***MODIFICATION REQUEST:
Sydney University Abercrombie
Precinct Redevelopment
Cnr Codrington Street and Abercrombie
Street
(MP07_0158 MOD 2)***

- Modification to the Business School Building

Director-General's
Environmental Assessment Report
Section 75W of the
Environmental Planning and Assessment Act
1979

December 2013

RENDERED ELEVATIONS
ABERCROMBIE STREET

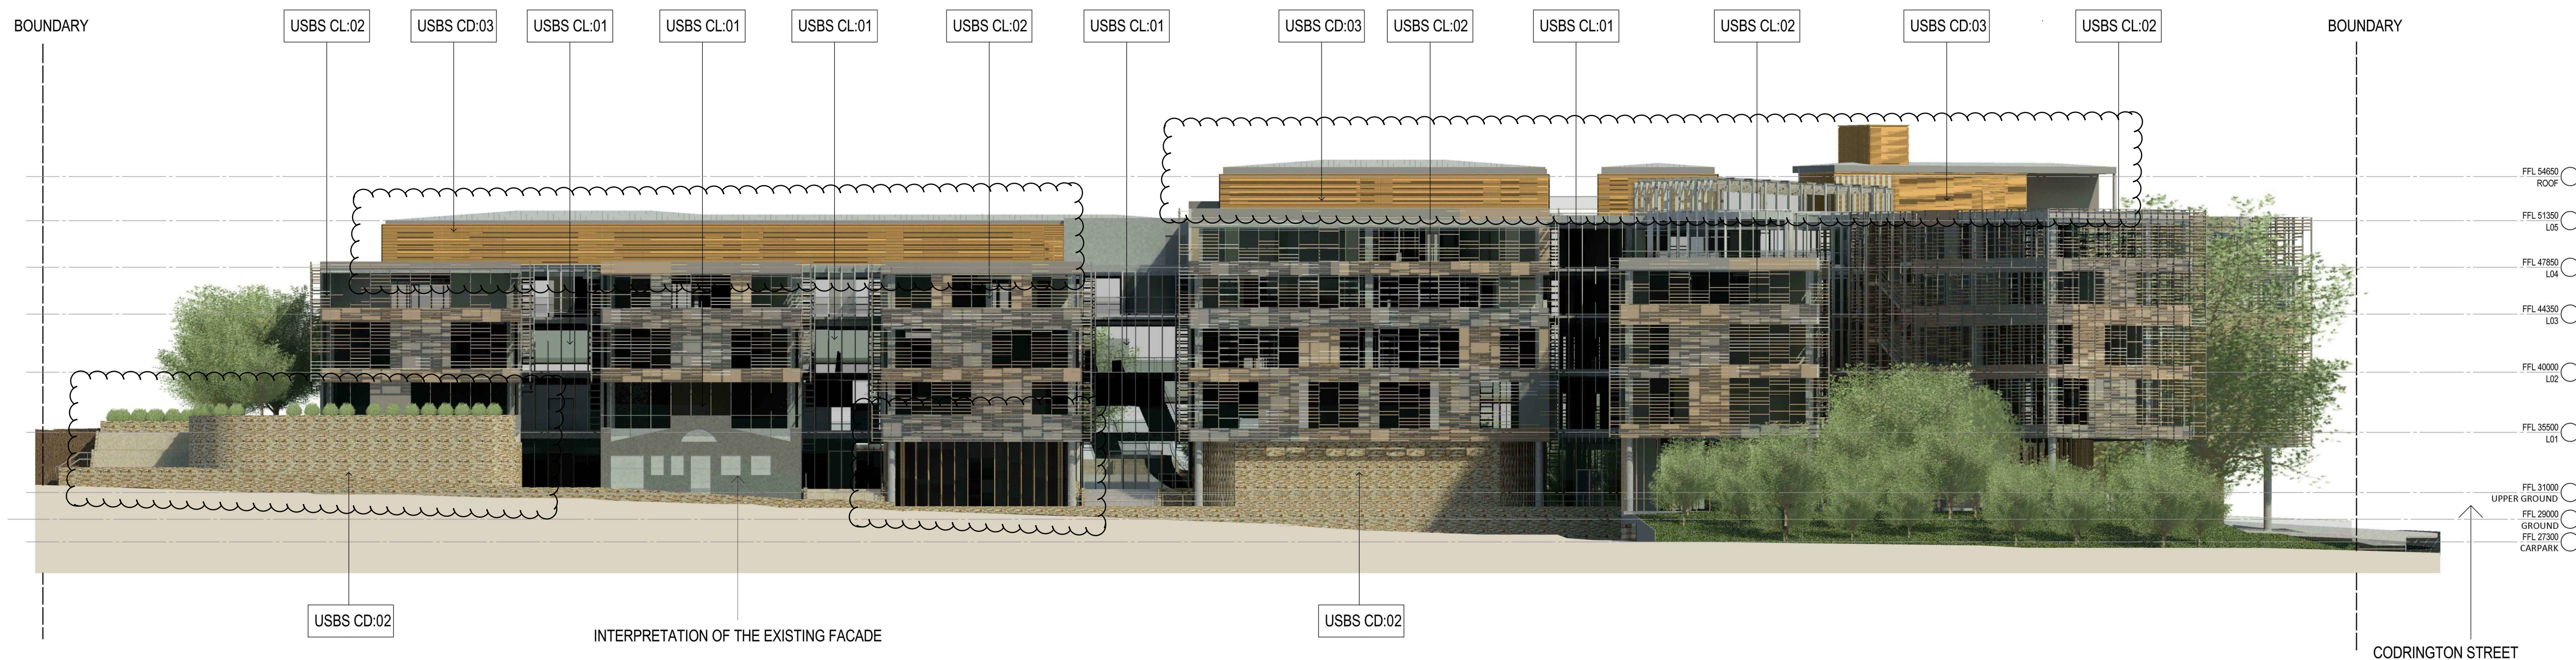
Council were generally supportive of the proposed building amendments, however council noted that the 'squaring off' of Block C removed the architectural design feature that tied this element of the building design to Codrington Street. In response, the proponent advised that the design change to Block C was required to accommodate an area of 900 sqm for the ground level learning hub, and that the adjoining external terraced area has been enlarged to

offset any loss of passive open space. The corners of Block C have also been rounded to maintain a design link to Blocks A and B (see **Figure 4**).

RENDERED ELEVATION
WEST ELEVATION
FACING SCHOOL

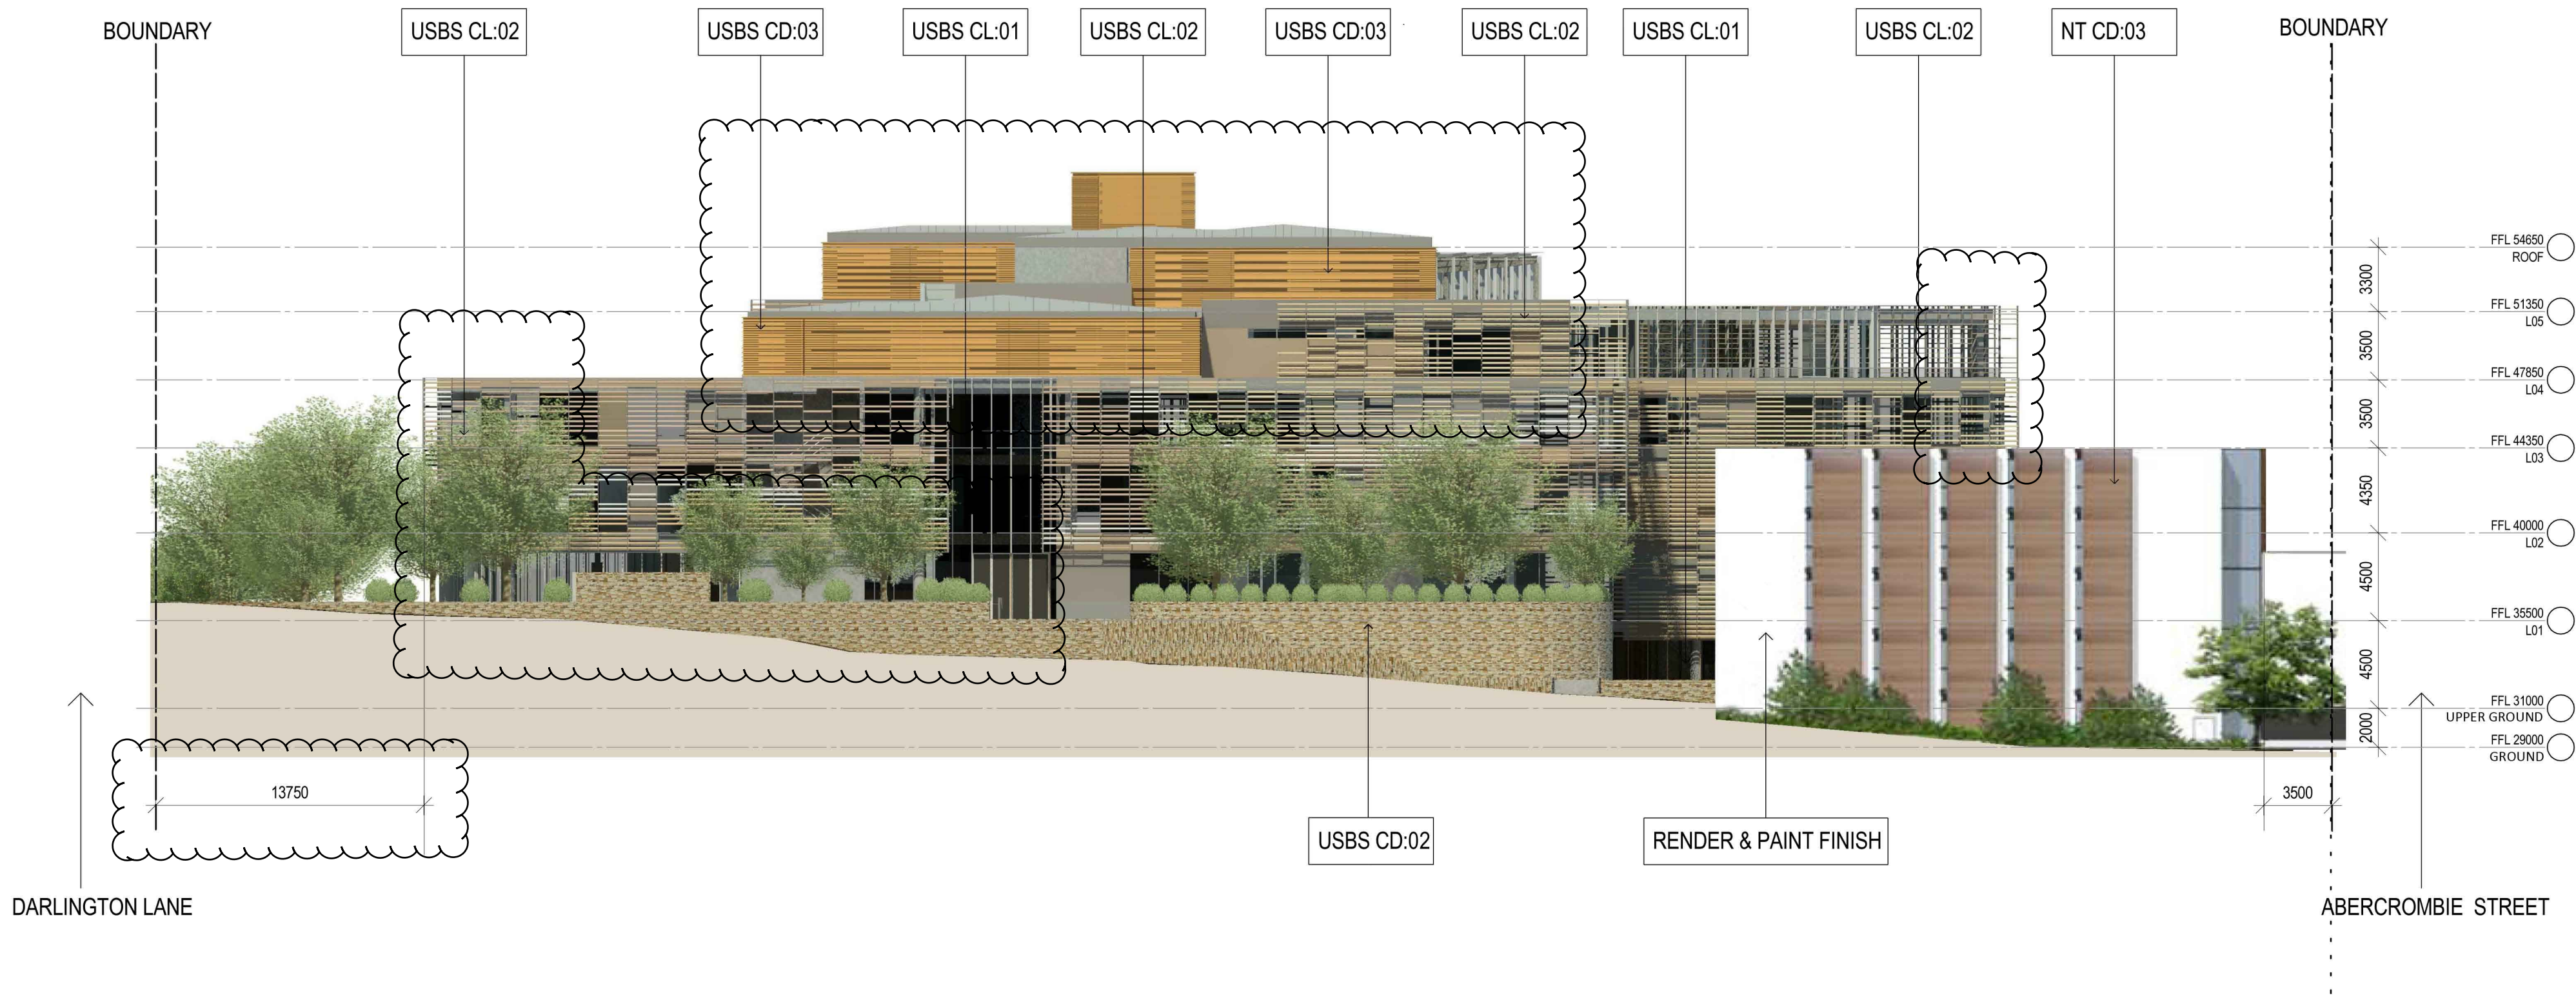
Objections were raised by the public regarding additional floor area, building bulk and height due to the proposed dining room on level 4 of Block C. The department acknowledges that a new dining room function has been introduced in Block C (see **Figure 13**). However, the dining room was relocated from Block B and will not result in additional floor area. Furthermore, the department notes that the setback of the entire Block C built form has been increased from Abercrombie Street by approximately 2.5 m, reducing overshadowing and bulk and scale impacts along the street. Moreover, the original approved design included an external louvered screen which wrapped the built form of the building, at times projecting above and around terraced areas.

Having regard to this, the department raises no objections to the proposed amendments to the location of the level 4 dining room to Block C. **Figures 12 and 13** also illustrate the differences between the approved and proposed modifications. It is evident from the figures that the proposed amendments will not result in additional bulk and scale impacts.

PLAN
LEVEL 01

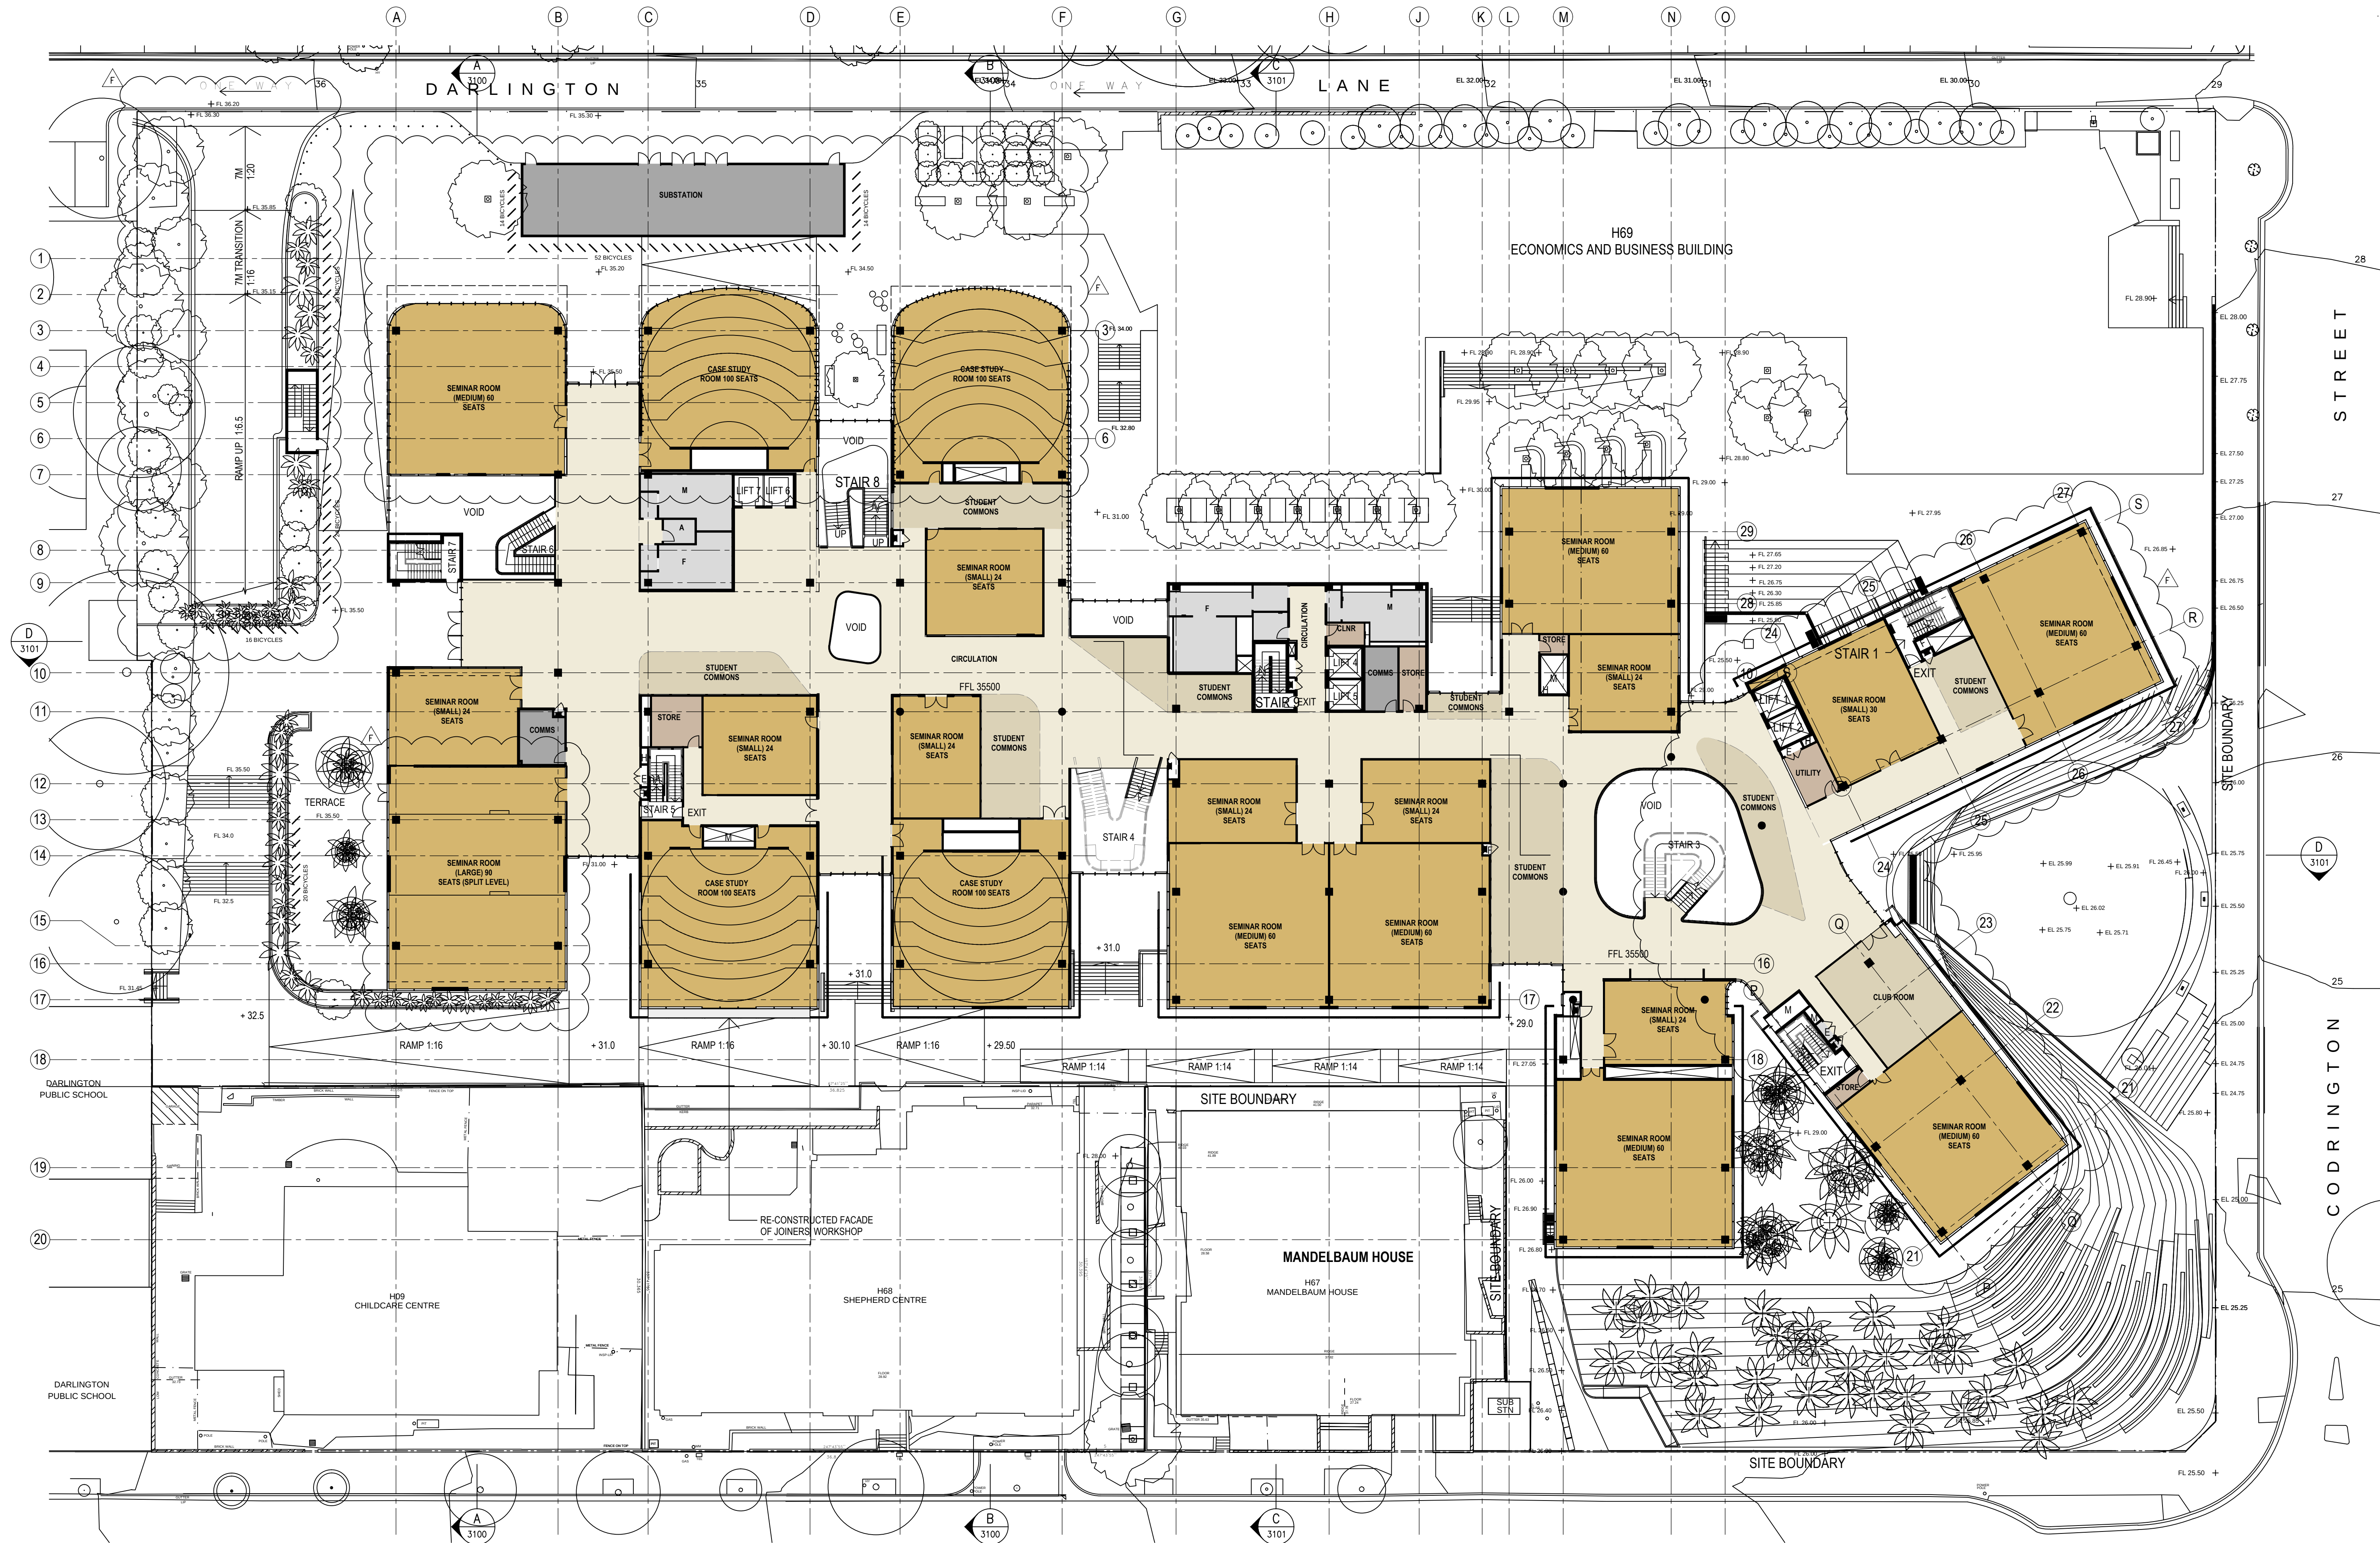
The modification application also proposes to elevate the approved substation from a subterranean position to level 1 (Darlington Lane), and council has noted that it will now become a prominent feature in the lane. Whilst no objections have been raised by council, in response to council's comments, the proponent provided further details with respect to the treatment of the façade of the substation structure, proposing a green wall on the eastern and western façades and surrounding native trees (see **Figure 14**).

The department acknowledges that substation structures are traditionally poorly treated within the streetscape. In this instance, whilst its elevation to Darlington Lane will make the structure more prominent, the proponent's proposed treatment response is considered acceptable and will assist in softening its appearance within the Darlington Lane streetscape.
